From: Martyn White
Sent: 08 May 2019 11:15
To: Planning.Responses
Cc: Zac Denton
Subject: CM/11/19/L

CM/11/19/L

This application relates to Listed building consent for alterations to an existing annexe building.

PROPOSED

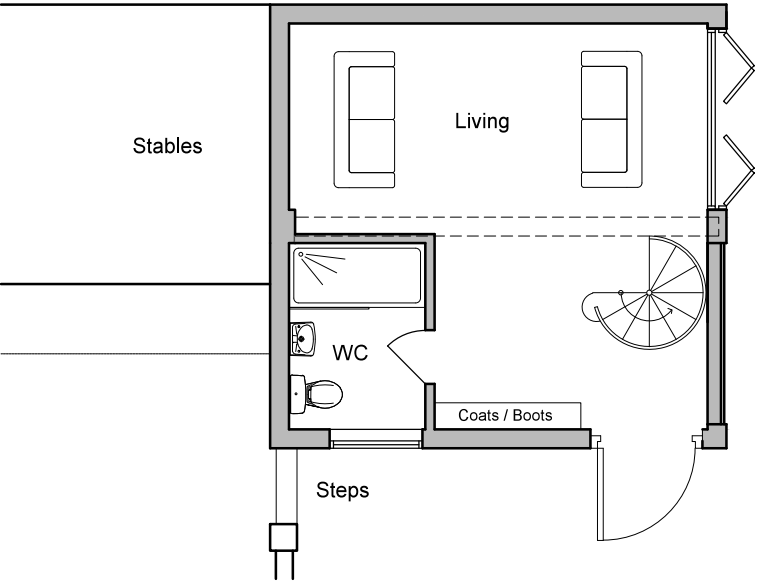
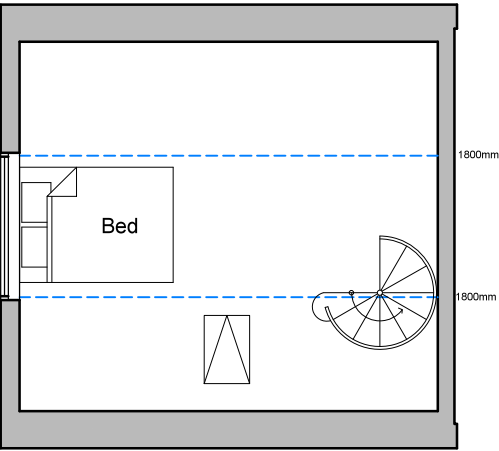
Further, the proposed internal alterations are such that they reduce the number of new walls which would have impacted upon the open character of the space. The proposal to retain the open character of the space can therefore be supported.

PROPOSED

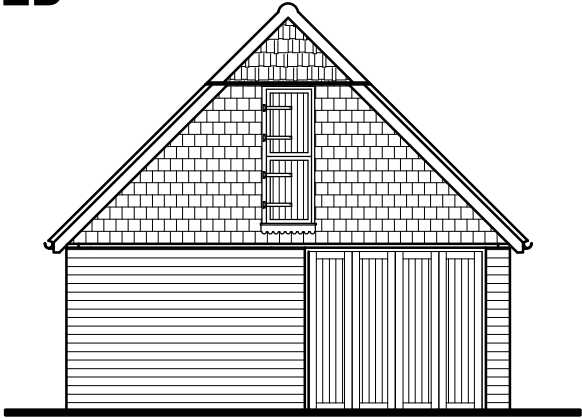
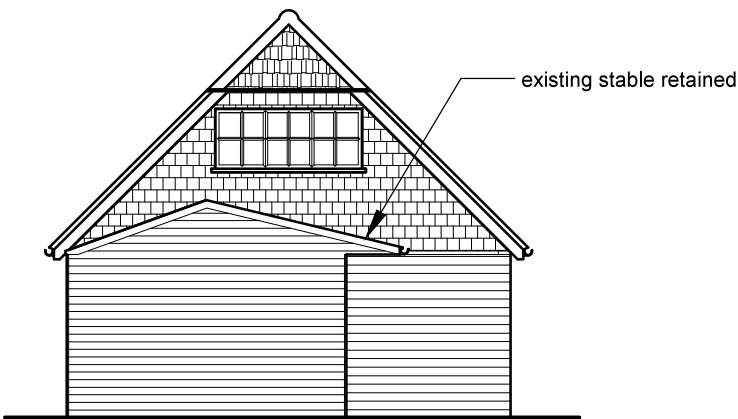
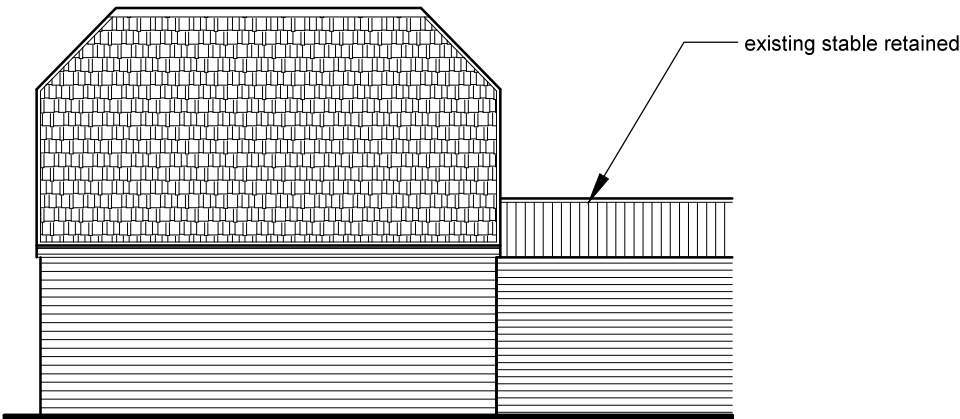
The external elevation of the proposed development seems to better reflect the character of the garage building. In fact the treatment of the garage door opening enables a large area of glazing to be provided whilst retaining references to the previous large opening, whilst screening it from view.

I also note that the current proposal is to reduce the number of rooflights to one. Such a concept is acceptable as it reduces the number of openings in the roof, allowing a more traditional appearance to be retained.

Whilst supportive of this application, it might be helpful to condition details of the materials and joinery, and ensure that the rooflight is of a conservation design.
